A R C H E T Y P E

15 October 2007

RE: Permit Review 468-470 Fore Street

Comments by Mike Nugent, Consulting Plans Examiner, City of Portland

A ELEVATOR SECTION  
SCALE: 1/4" = 1'-0"

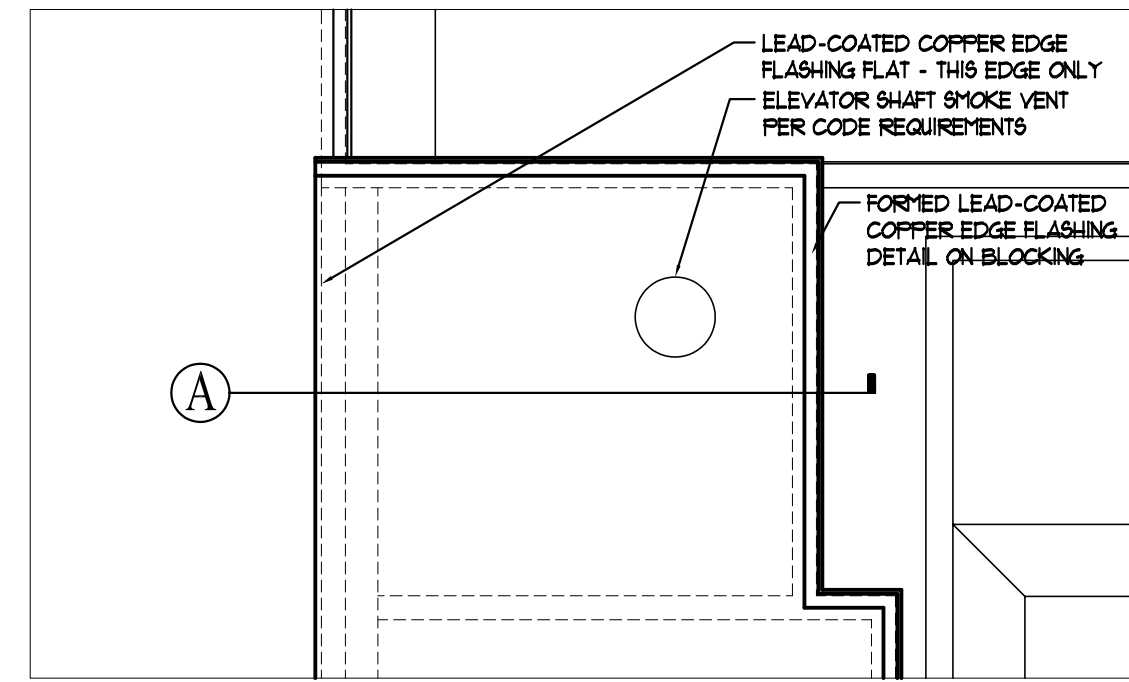
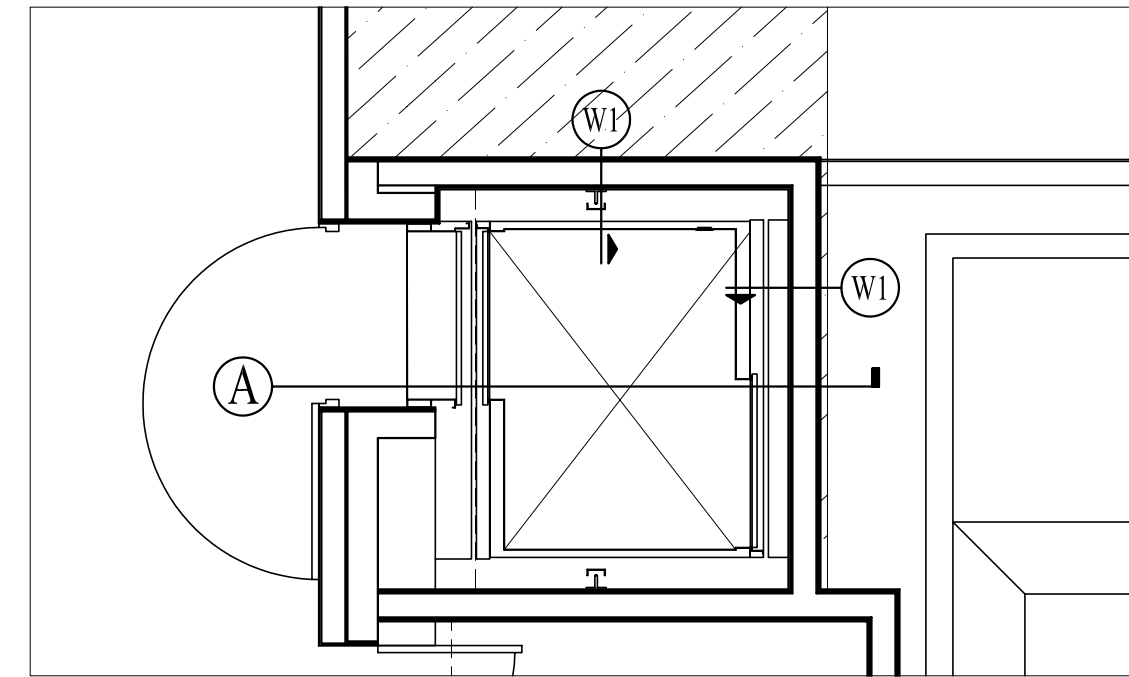
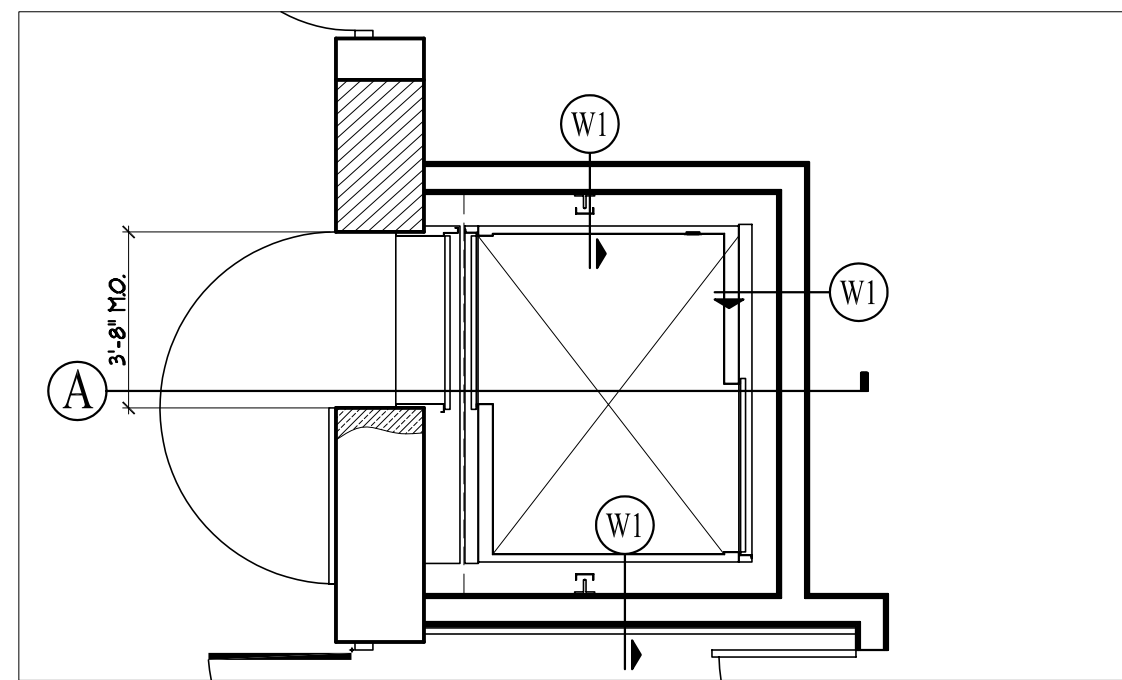
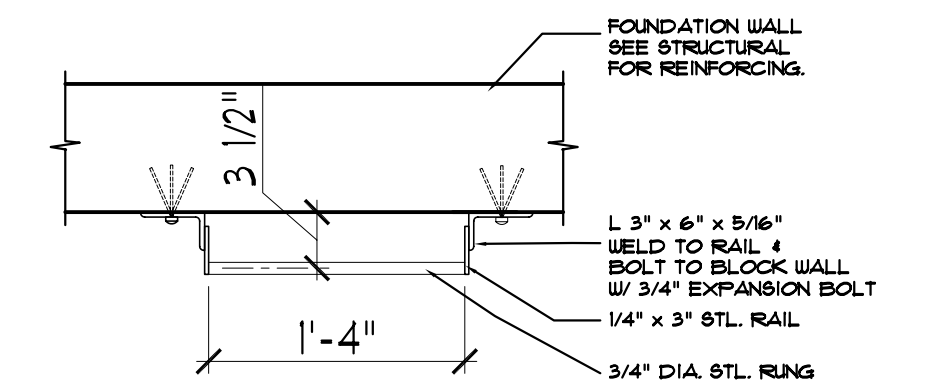
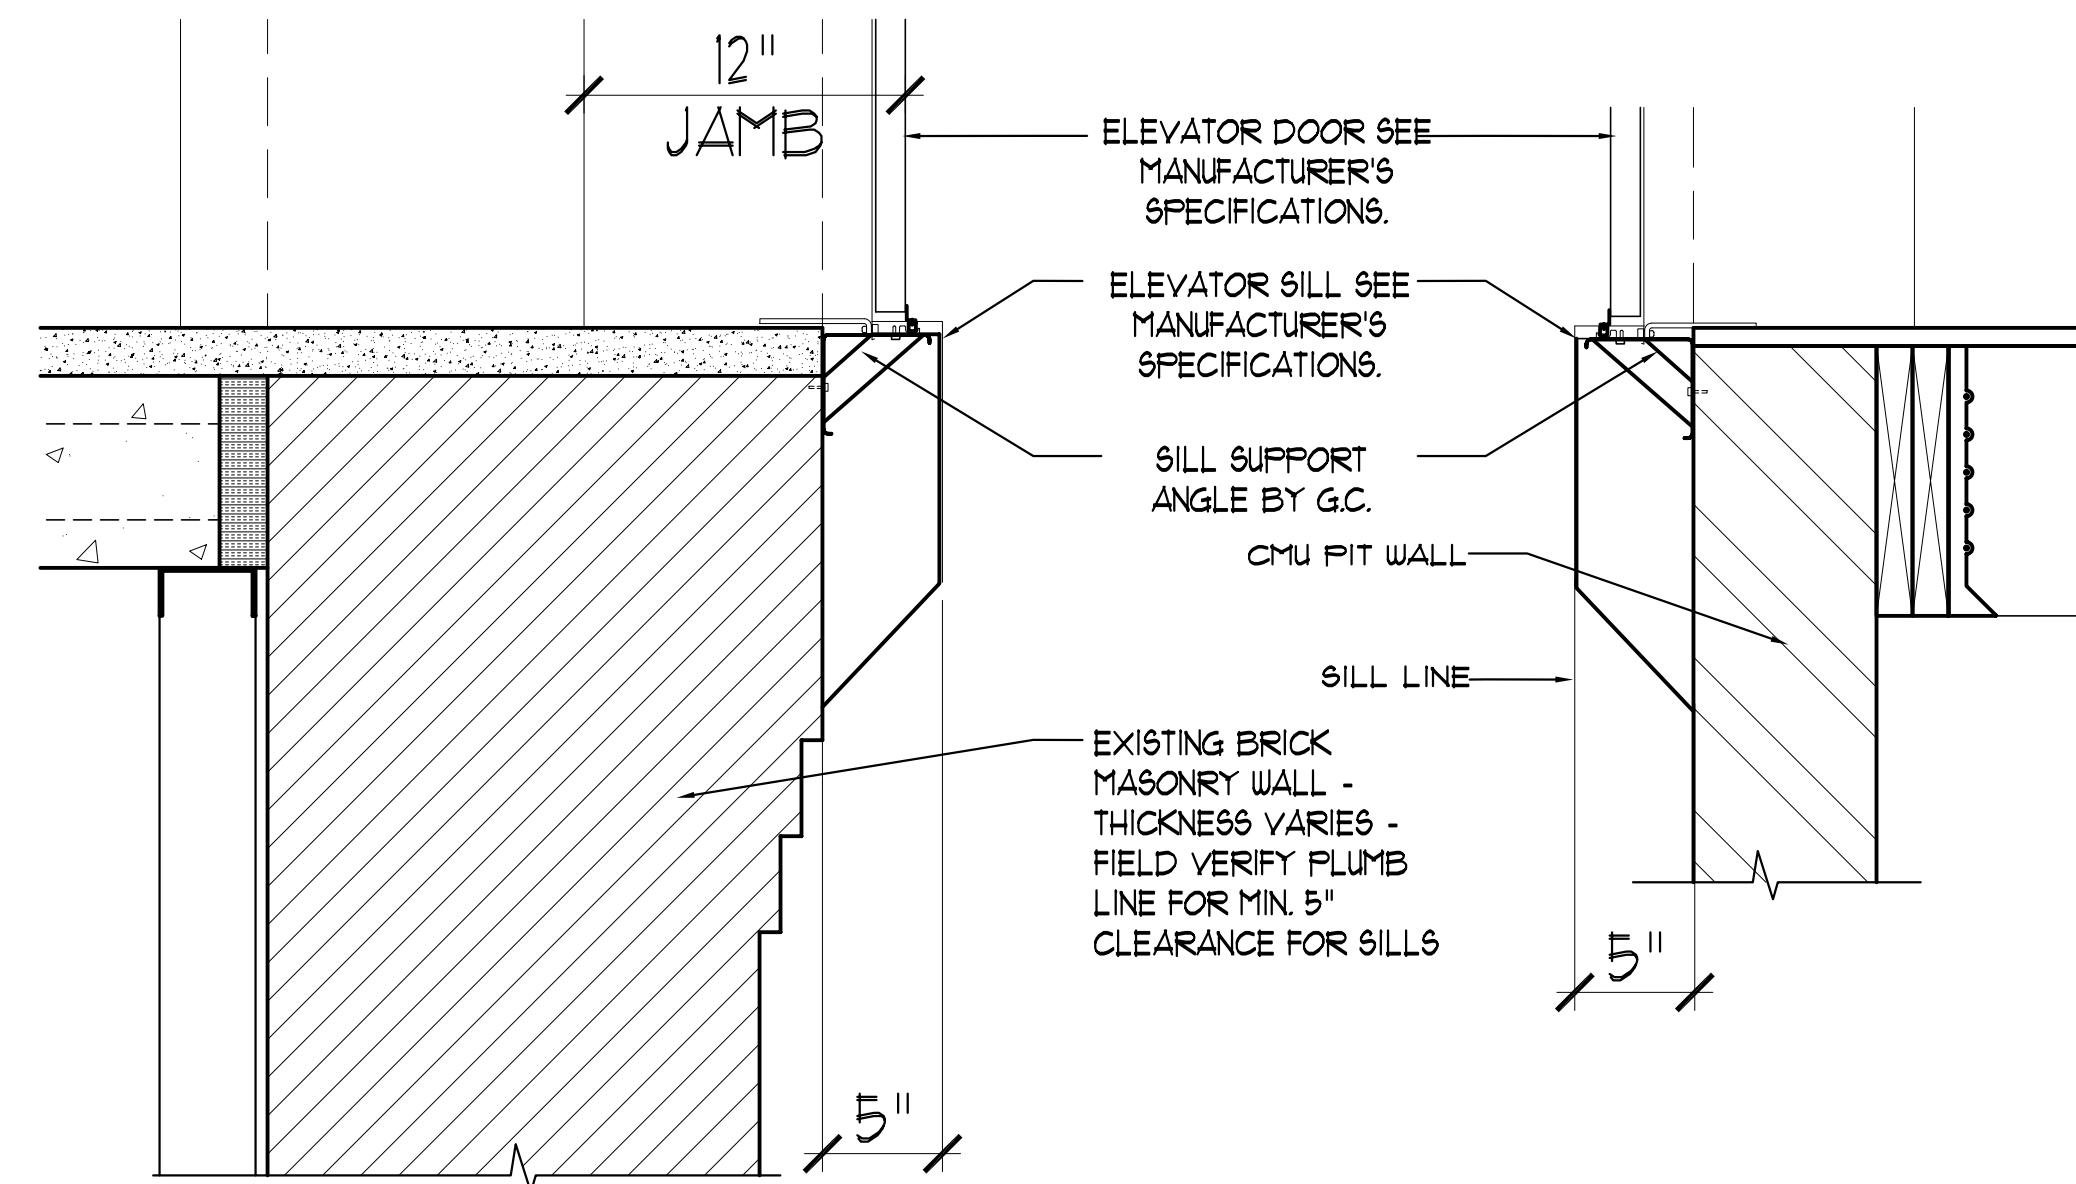
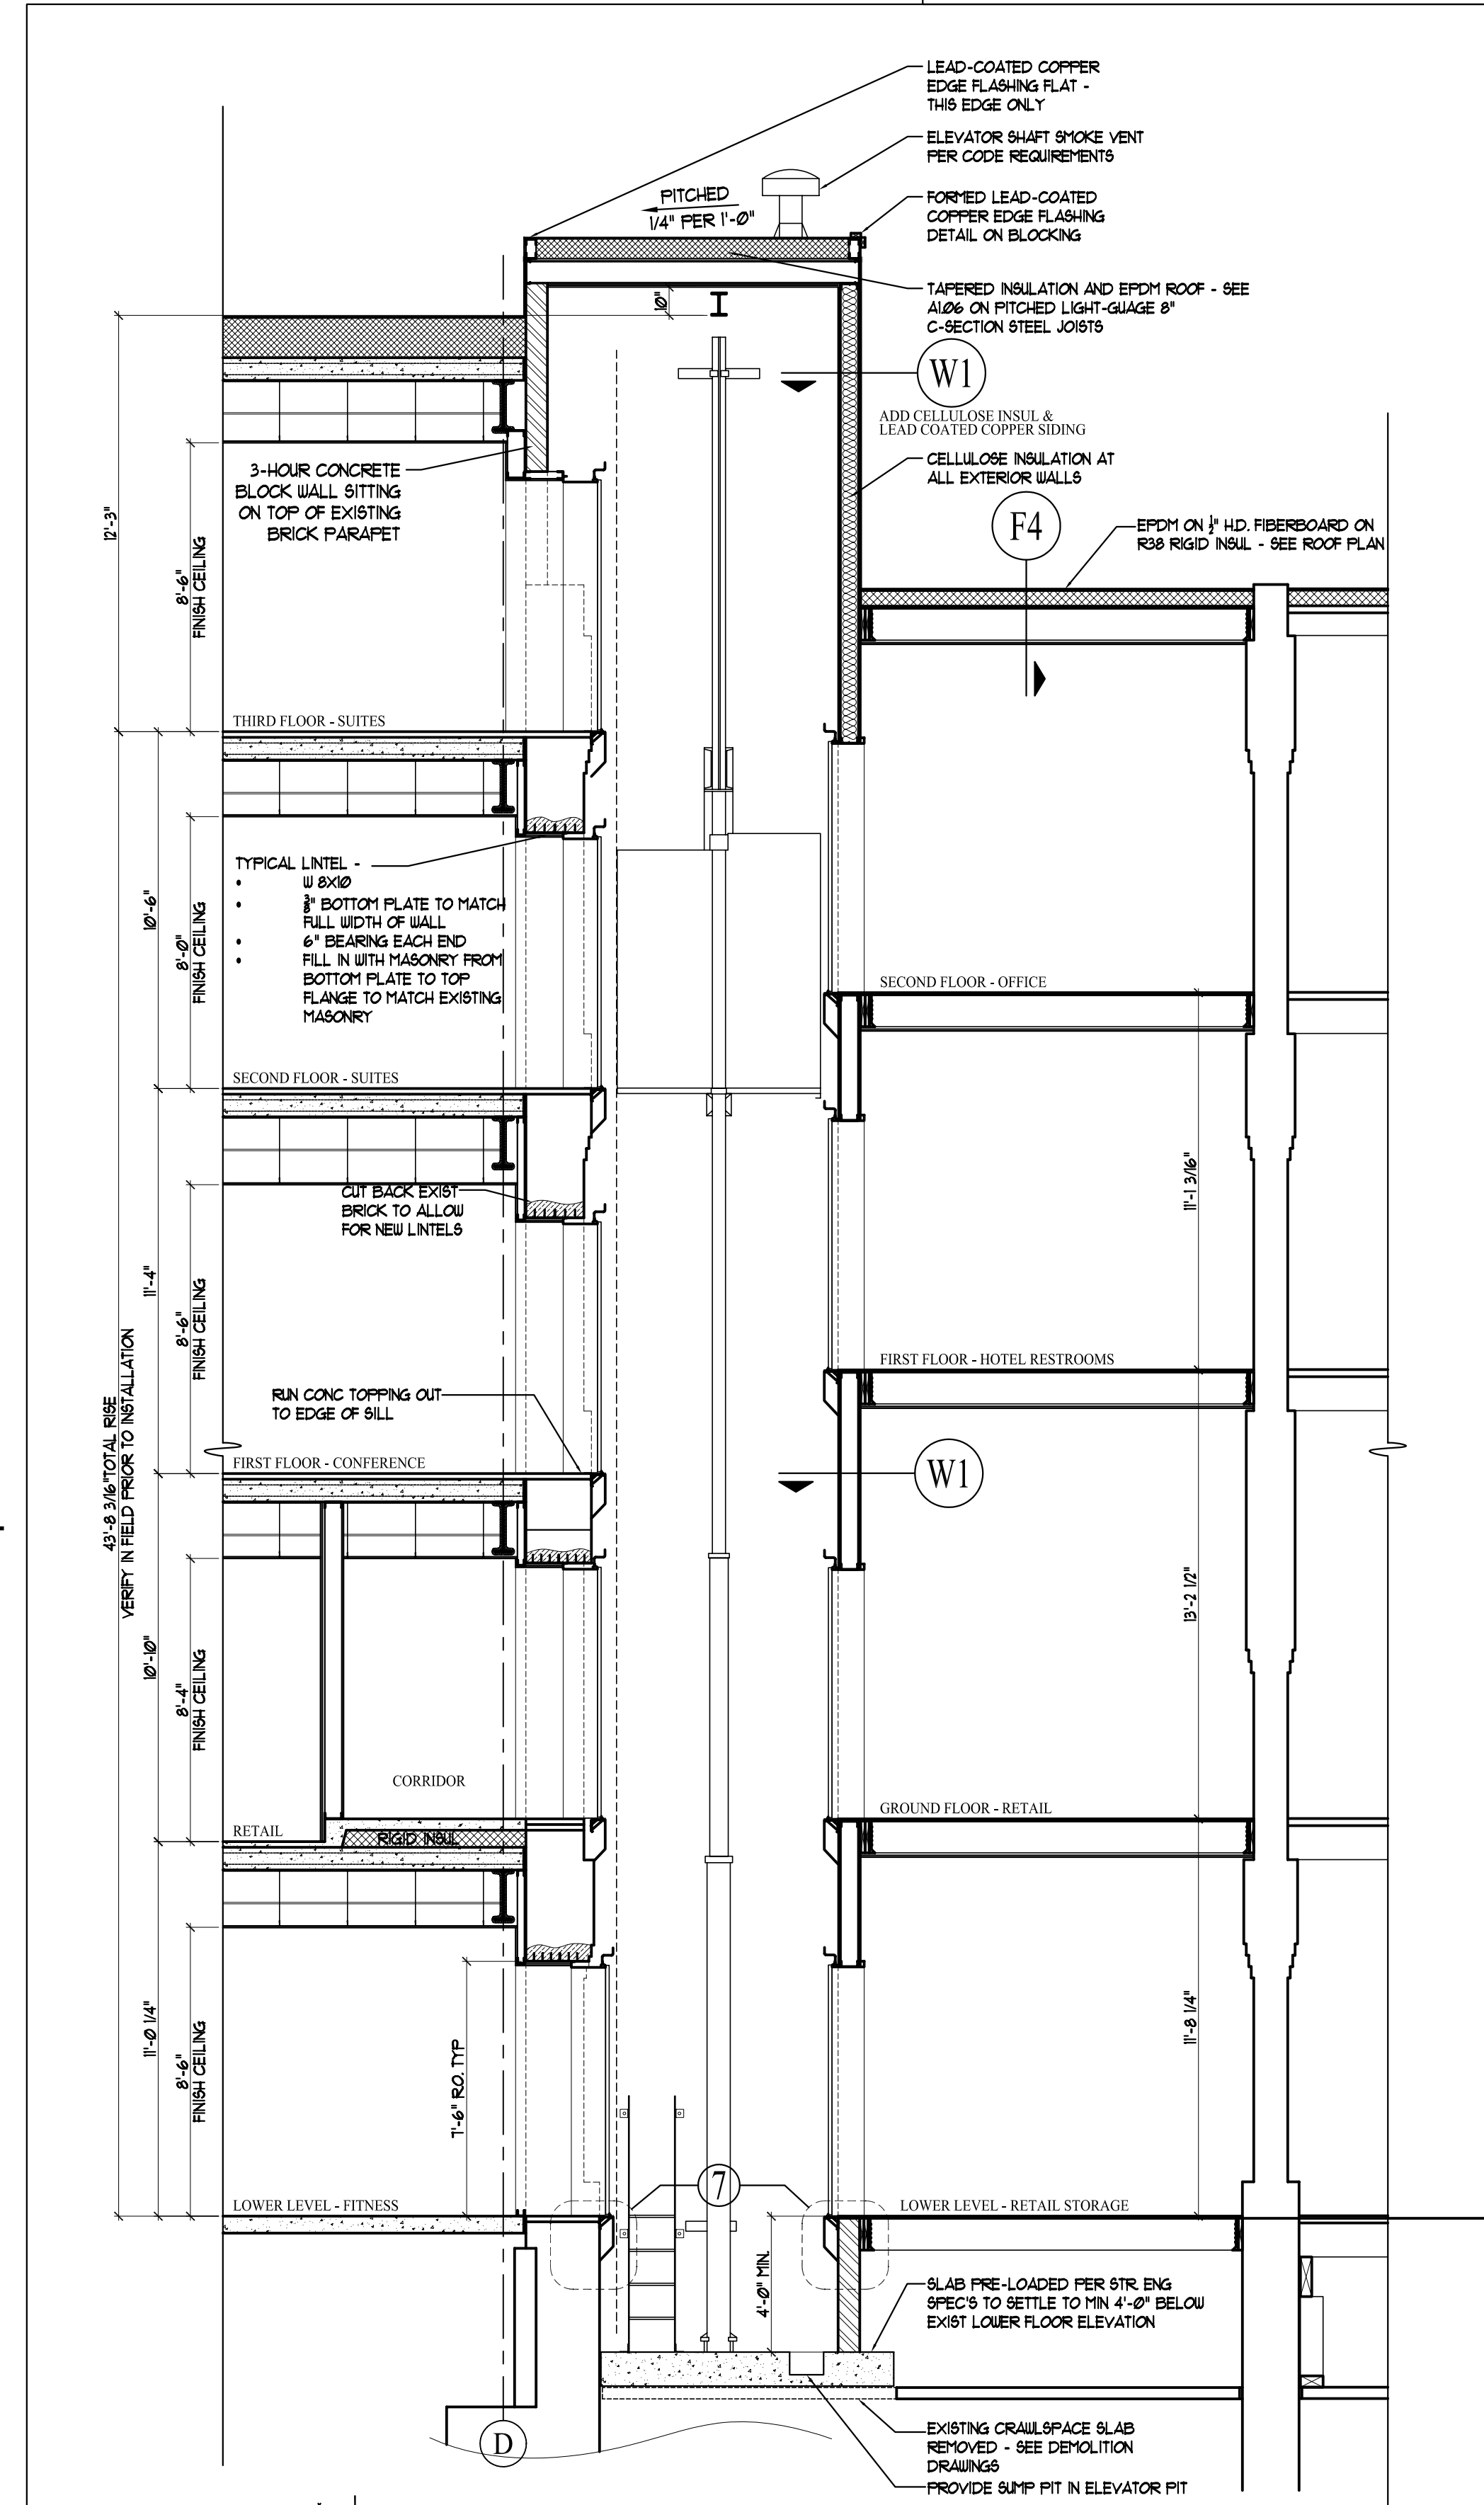
4) Item 13: Unfortunately, we (us and MSHA) had two different opinions from IBC on this so we asked for a formal. It turned out to be a contrary opinion for this specific situation for the building that fronts on Oxford St. near Pearl. The final ruling from the IBC was that because there is a required accessible floor that if four stories above "a level of exit discharge" the additional equipment is required. I'll ask City Hall staff to provide a copy for you. **Response: Regarding accessible means of egress by elevator, we have again reviewed the code requirements and have the following comments:**

- 1. The proposed renovation and addition of an elevator to 470 Fore Street is in a 3 story building with a daylight basement. The code requirement for required accessibility is for buildings four or more stories above the level of exit discharge. The level of exit discharge through the stairway is on the 1st floor only. The person in distress is carried down three stories or up one story. There is no egress from the 1st floor through the basement. There is direct access from the basement to the exterior. I conferred with IBC and they agreed with our analysis.**

- 2. Furthermore, the proposed renovation meets Section 1007.2.1 Ex 1 as it would be both sprinkled and provided with a horizontal exit into 468 Fore Street. I conferred with IBC and they agree with our analysis.**

- 3. My observation of the Pearl Street building is that it is a 4 to 5 story building both by definition and use and is not an accurate comparison.**

**W7** 3 HOUR WALL ASSEMBLY

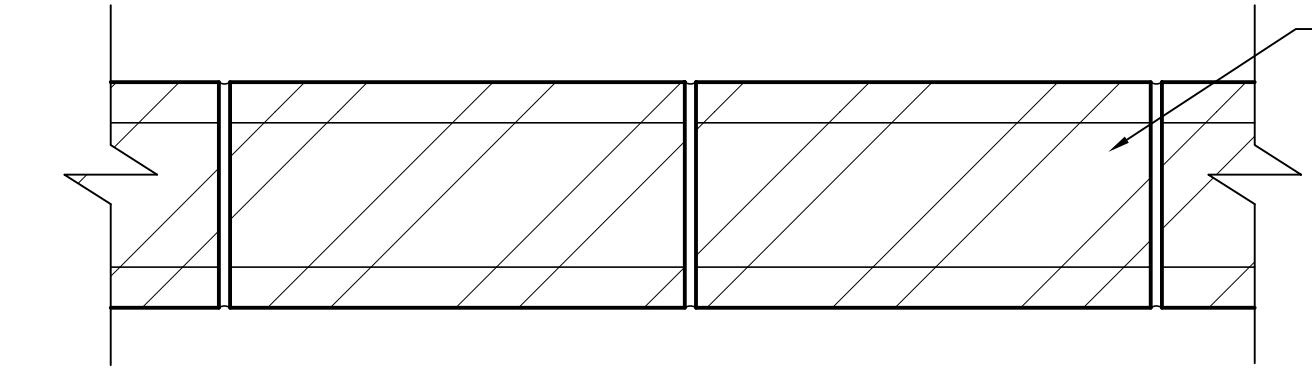
1) Item number 4: This seems to be a potential problem. Without opening protectives that meet table 715.3 we have no firewall. Please research this further and either come up with an alternative design or a code justification that supports your design. **Response: The doors we are using in the 3-hour fire wall (highlighted in red on the attached drawing) are typical 3-hour rated doors – hollow metal doors, with passage hardware, on magnetic holdback (door to elevator opening only), and will be smoke-sealed with gaskets. This is all part of the door hardware supplier's scope of work. Our consultant is presently writing this all up in a letter that I will forward to you upon receipt.**
